Our ref: Hanson Tweed Sand Plant Expansion (SSD-10398)

Subject: Request for Additional Information – Amendment Report

Following submission of the Amendment Report for the Tweed Sand Expansion Project (SSD - 10398), the Department sought advice from relevant government agencies. Copies of the advice received from government agencies are available on the project webpage at the link below:

FIGURE 3: EXISTING & PROPOSED HTSP FOOTPRINT

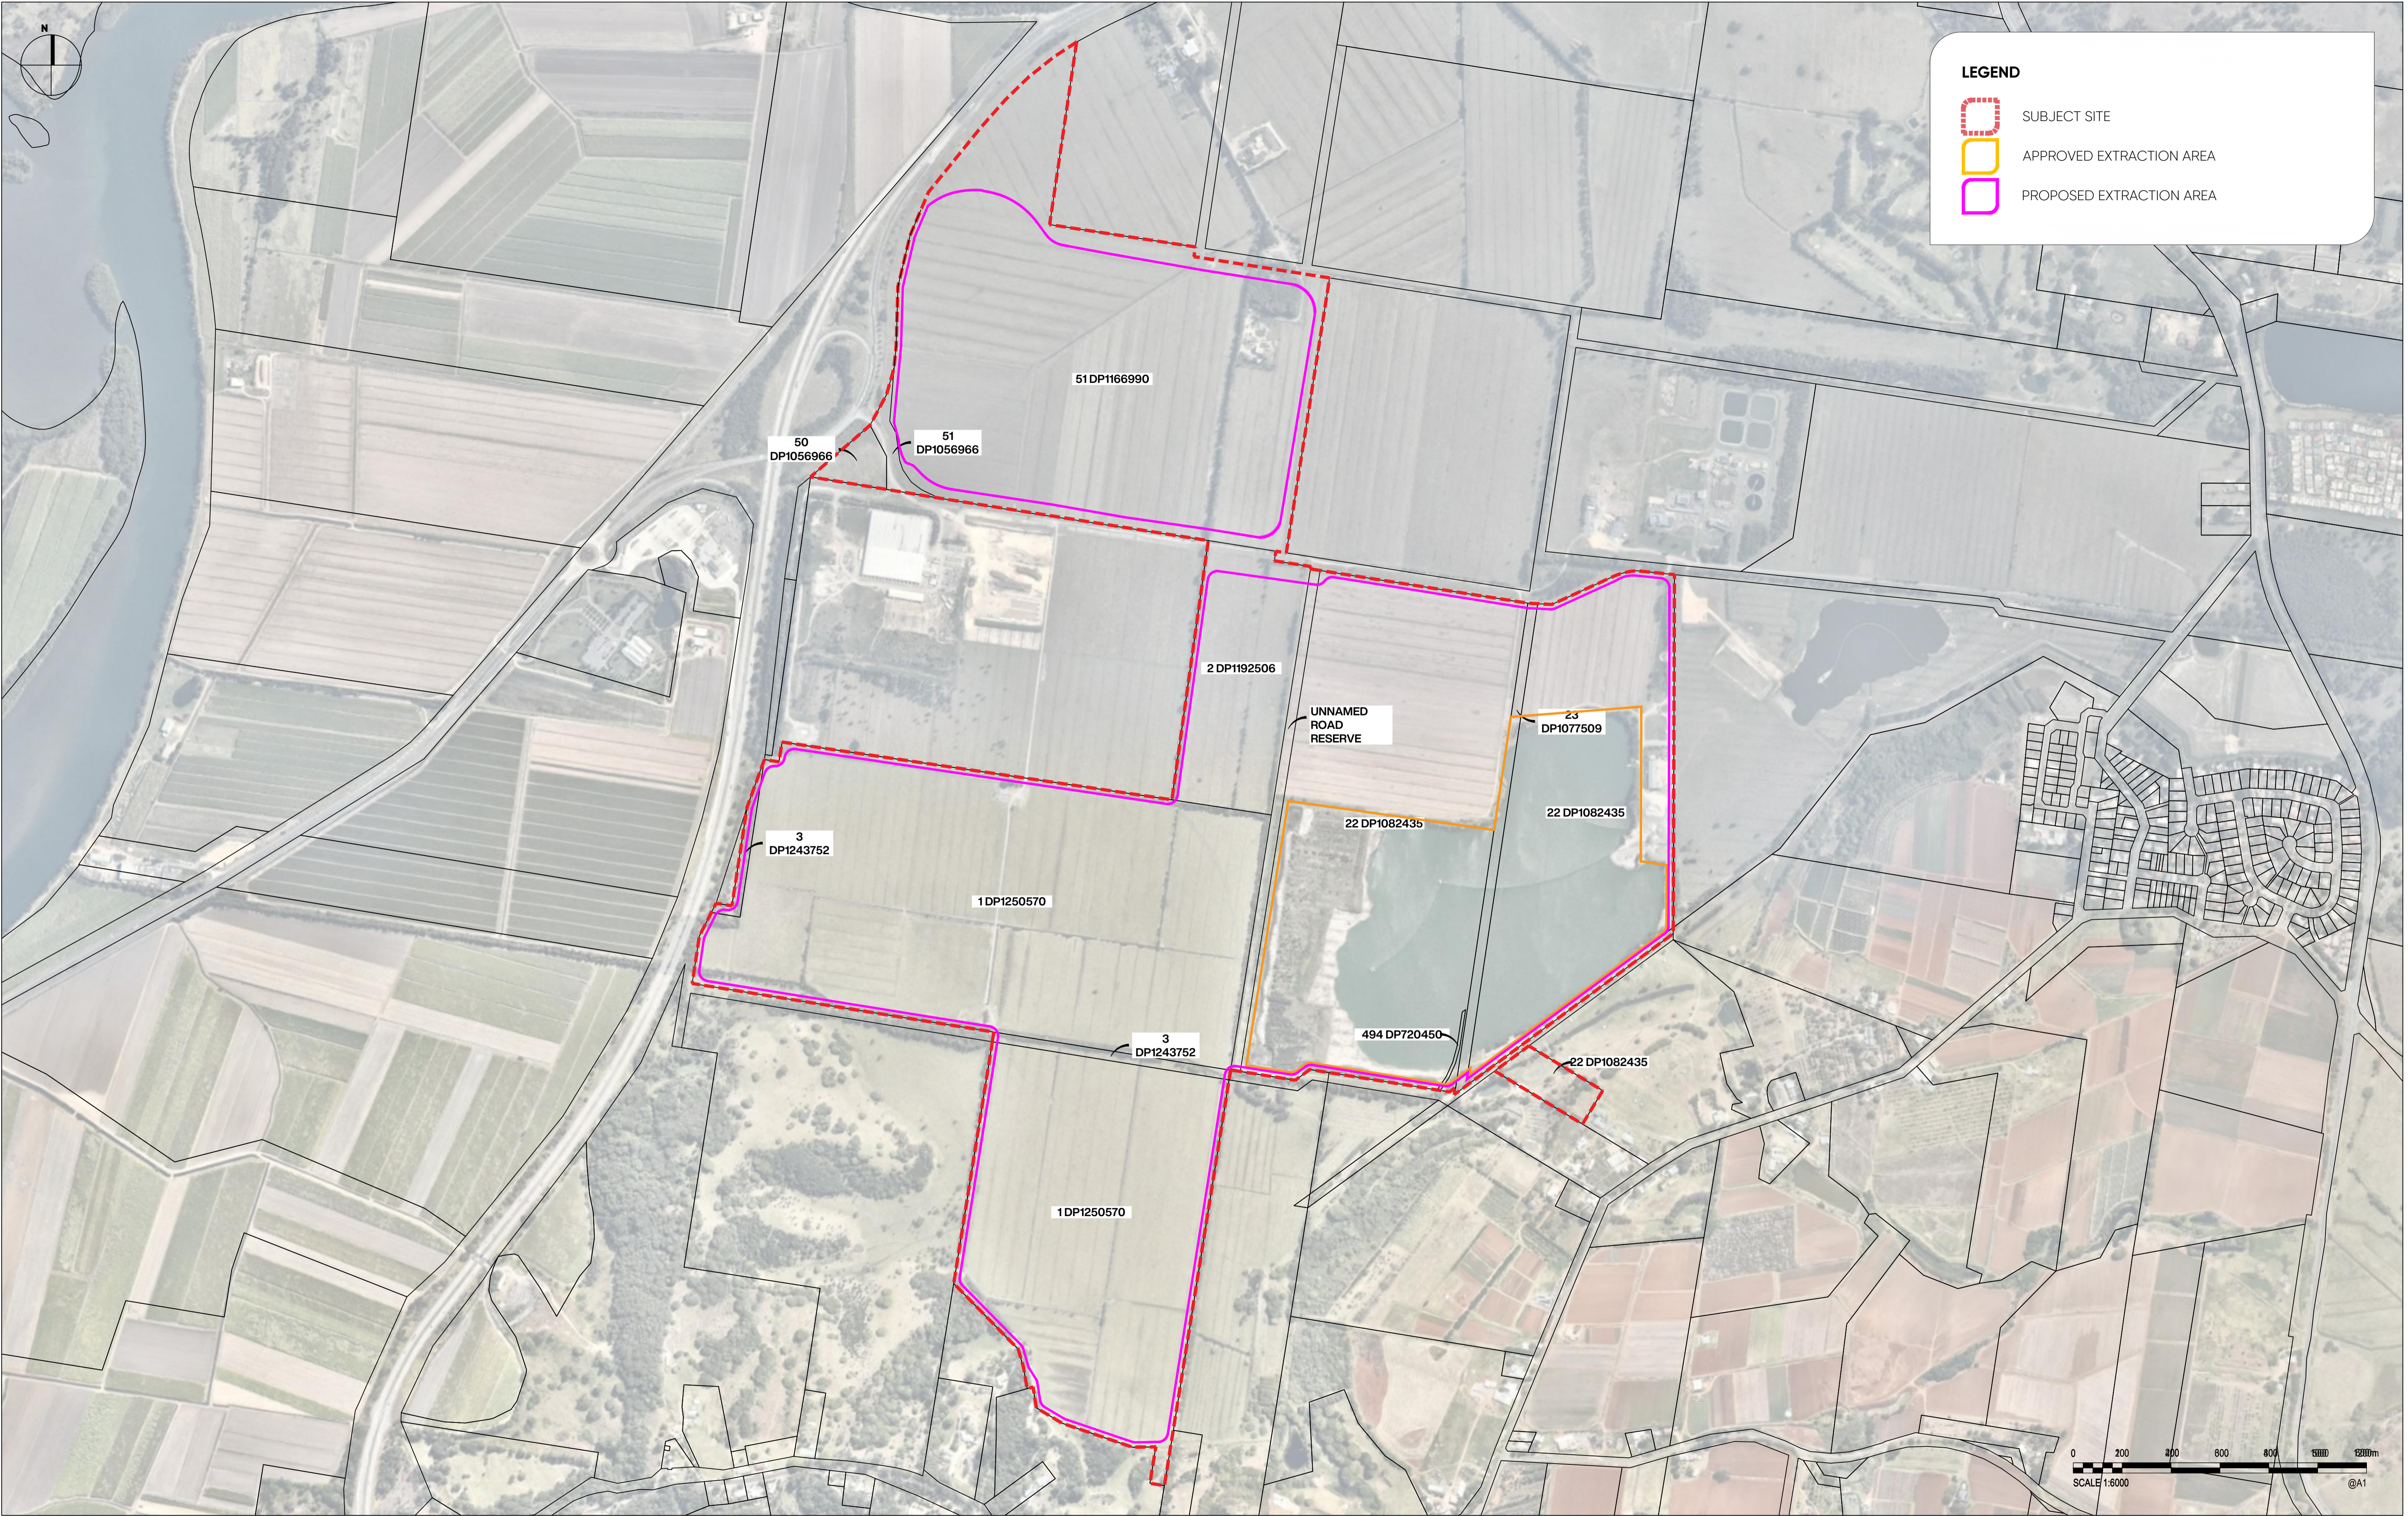
1. The Amendment Report reconfigures the Tweed Sand Expansion Project to remove the unnamed road reserve from the project. While the documents provided show that the unnamed road reserve would no longer be included within the extraction lake, it appears that the proposed haul road would cross the unnamed road reserve, as shown in **Figure 1** below by the yellow circle.

Please clarify whether the haul road will cross the unnamed road reserve. If the haul road does cross the unnamed road reserve, then it would still form part of the Project and landowners' consent would be required.

If the haul road does not cross the unnamed road reserve, then please clarify the land parcel it would be located within and advise whether landowners' consent is required.
